REPORT UPDATE

Application No: EP/90/09/

PLANNING APPLICATION REPORT**REF NO:** EP/90/09/**LOCATION:** Churchfield
Station Road
East Preston**PROPOSAL:** Demolition of existing buildings & residential redevelopment to provide 14 no. houses & apartments, with associated parking & open space.**SITE AND SURROUNDINGS**

" Church Field " Station Road, East Preston
Typical Sections

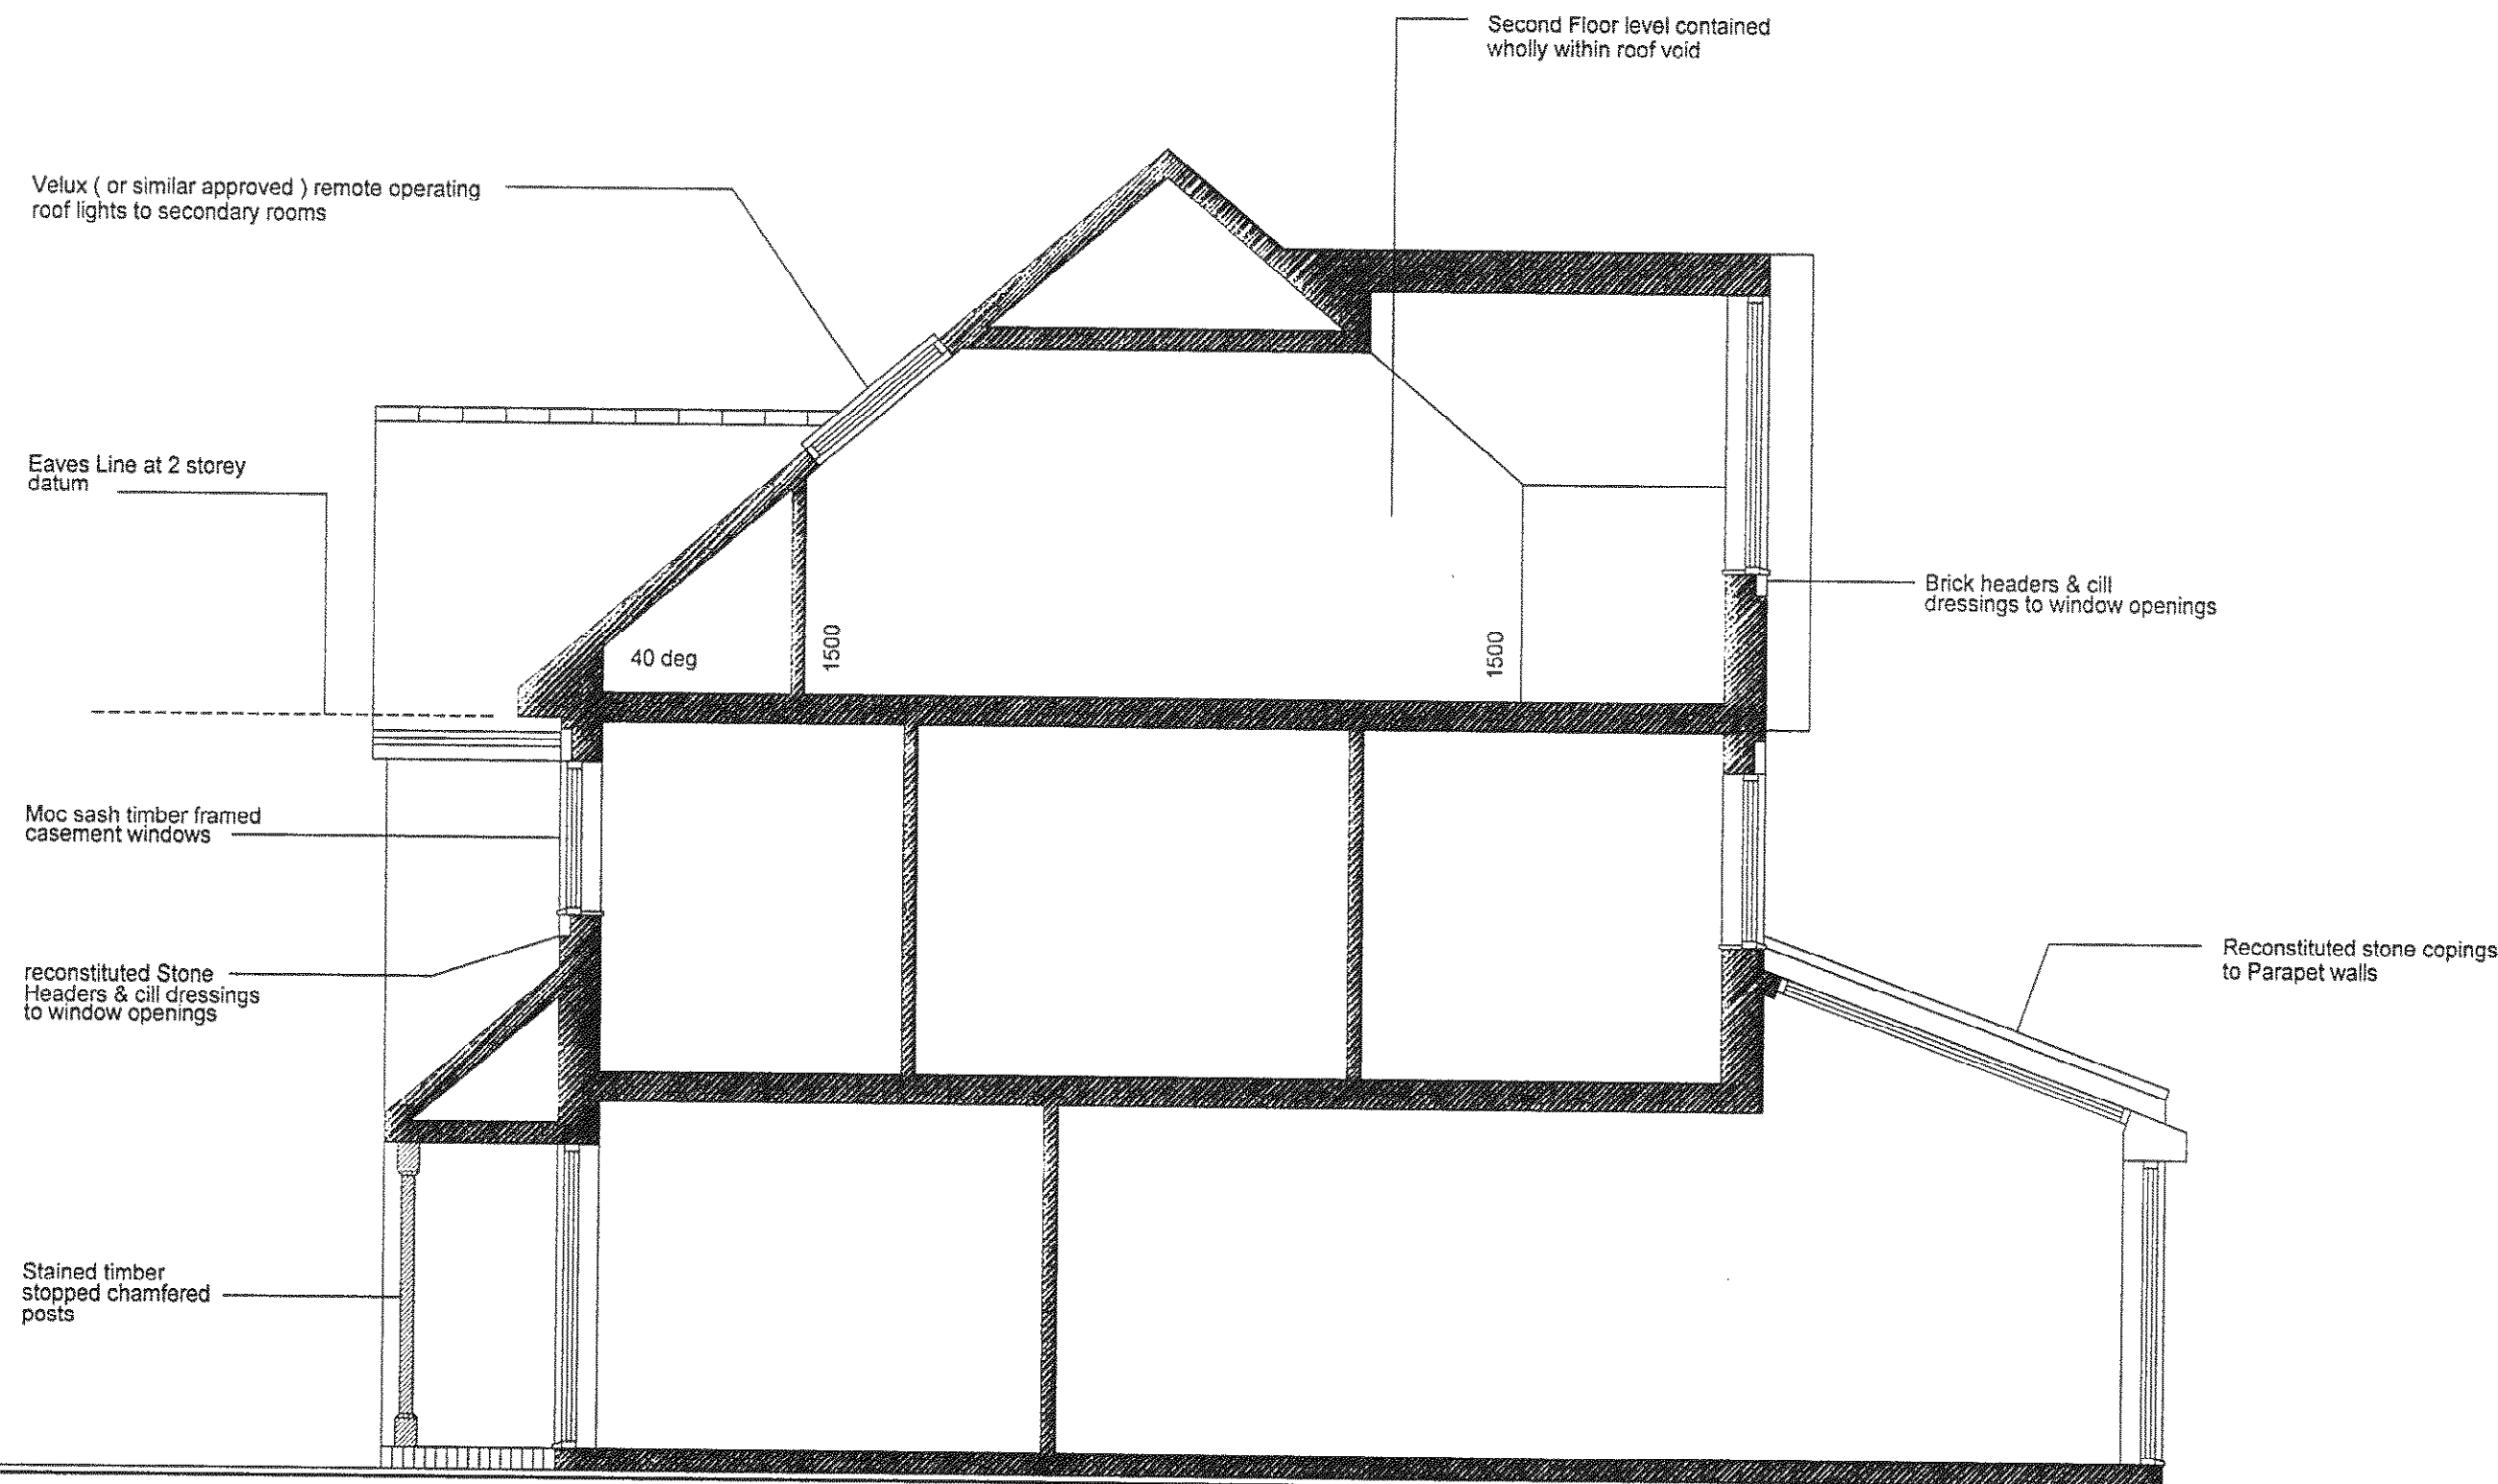
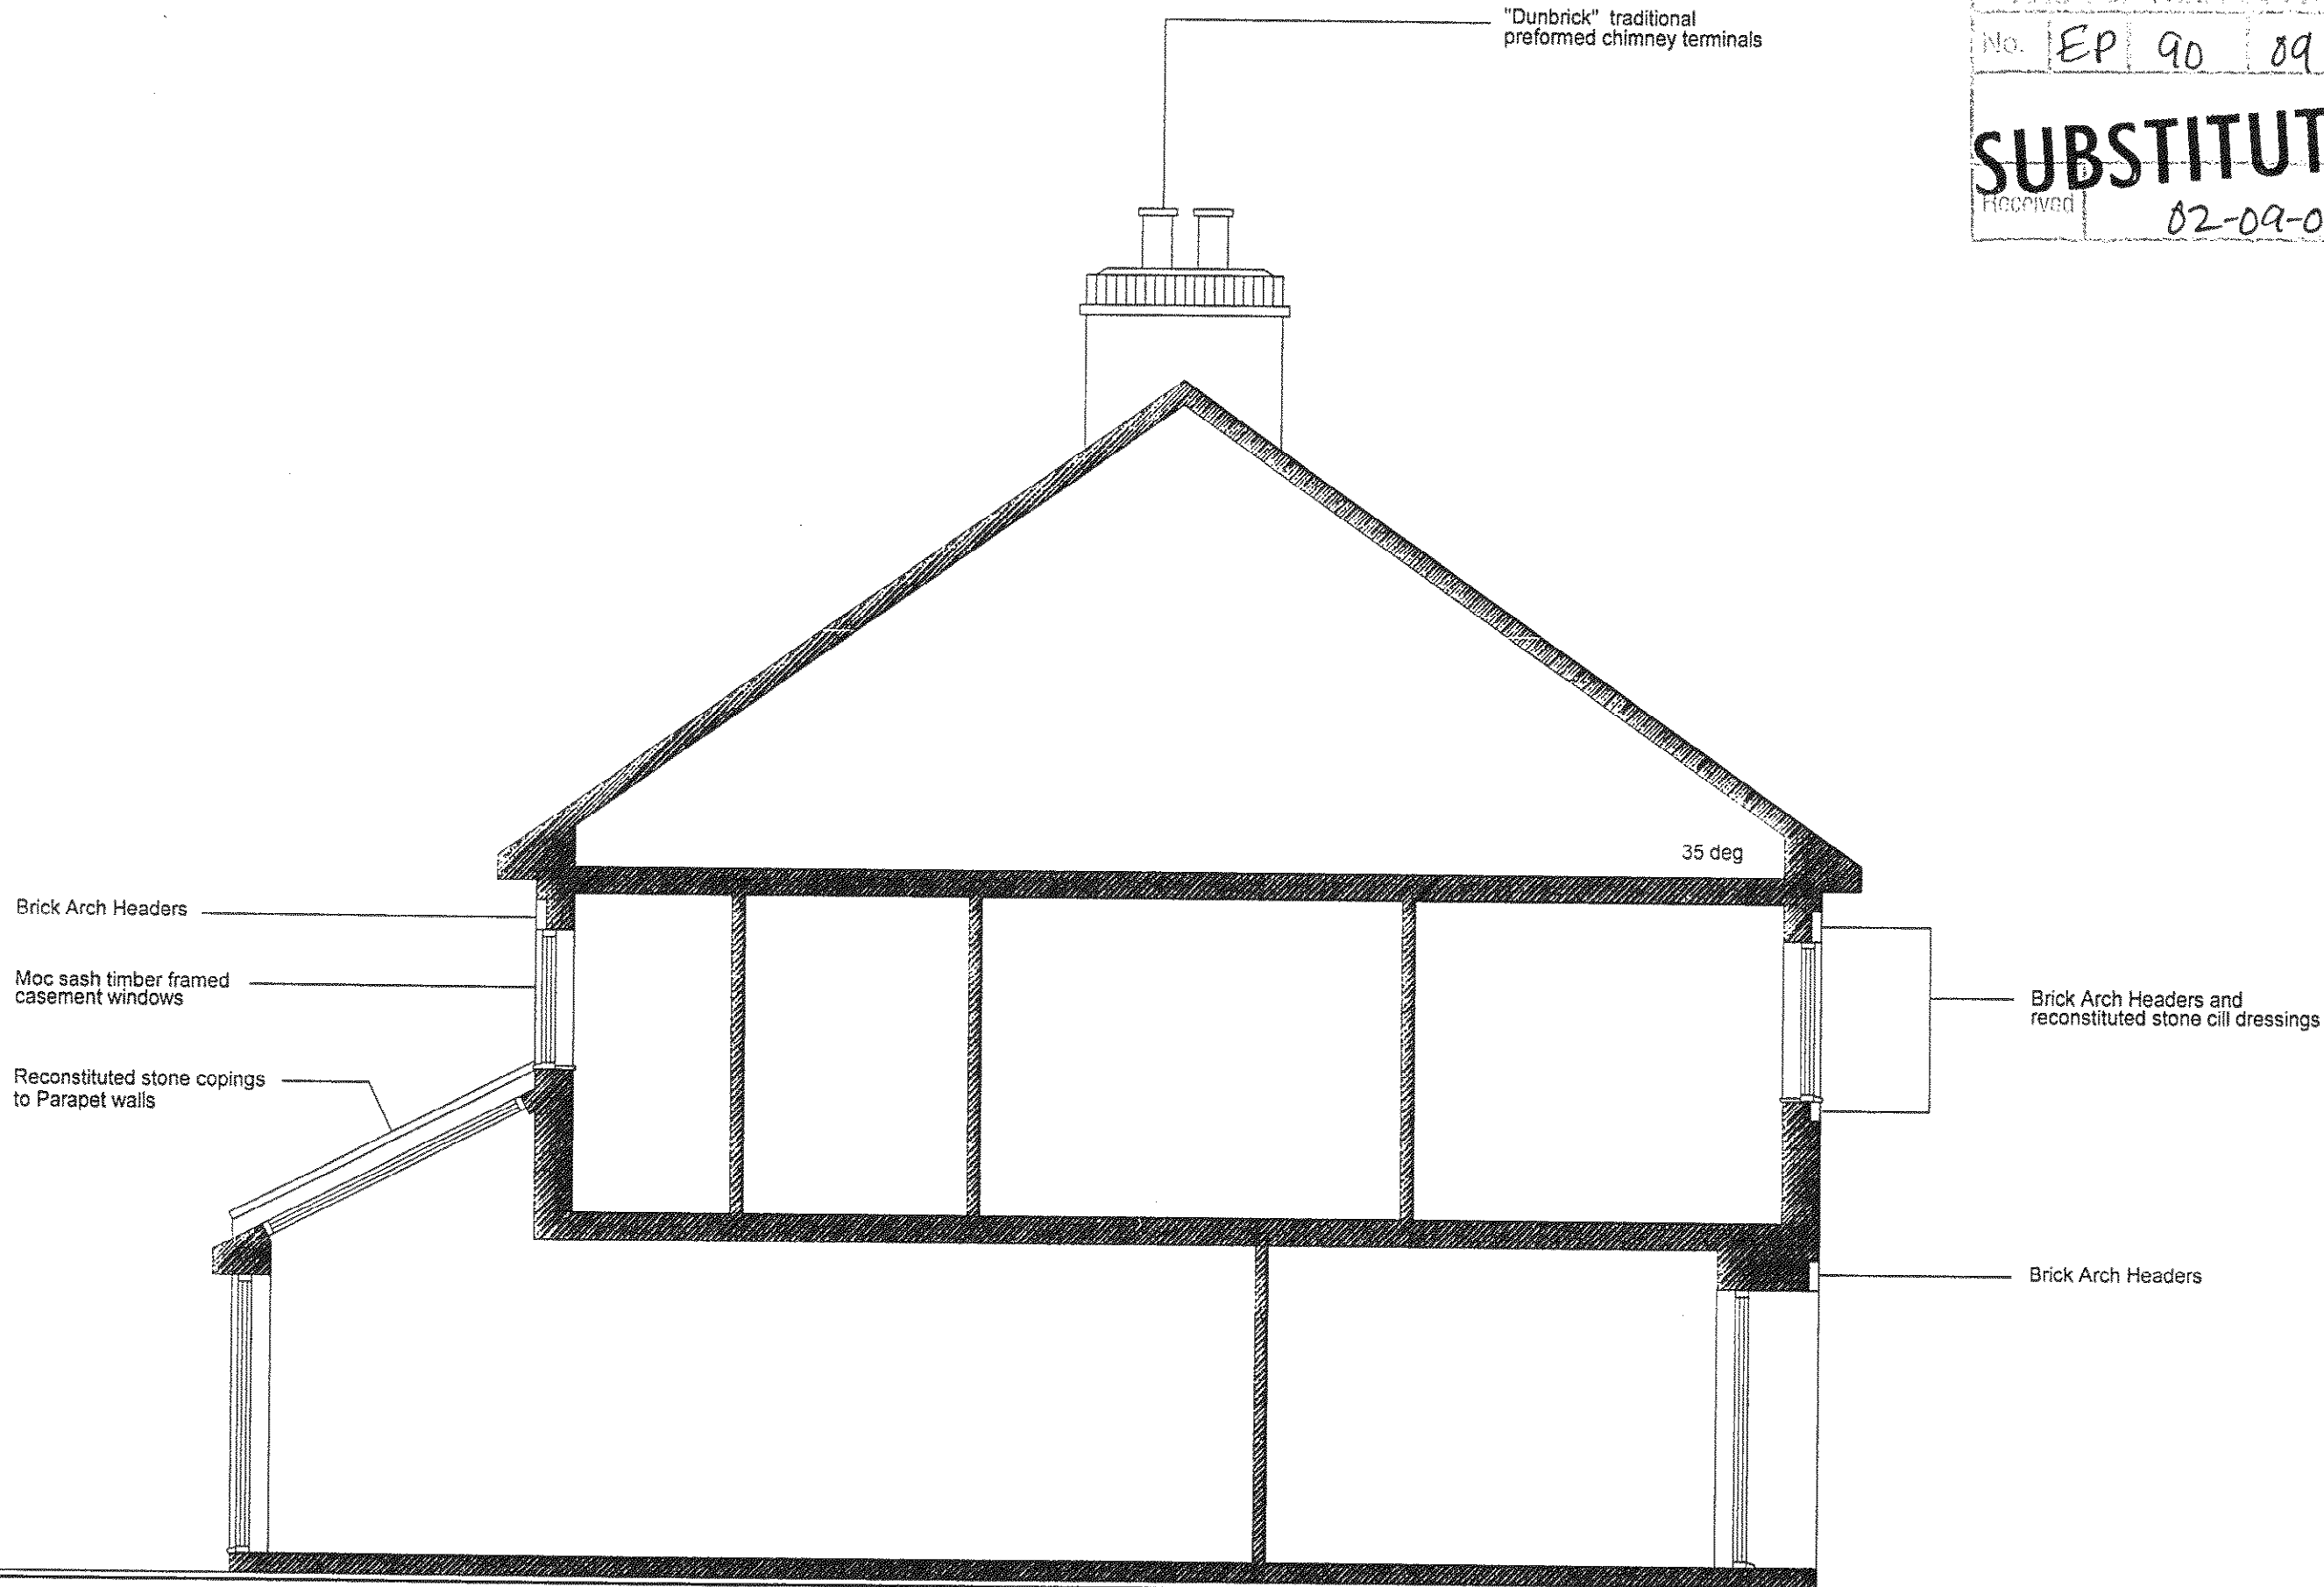
Amended elevational plans have been received which delete the balcony to the 2nd floor of the flats; delete the dormers and doors which were associated with this balcony on the 2nd floor; removed the 2nd floor built link section between the terraced housing and the flats.

The amended elevations are acceptable design changes brought about following discussions with the LPA.
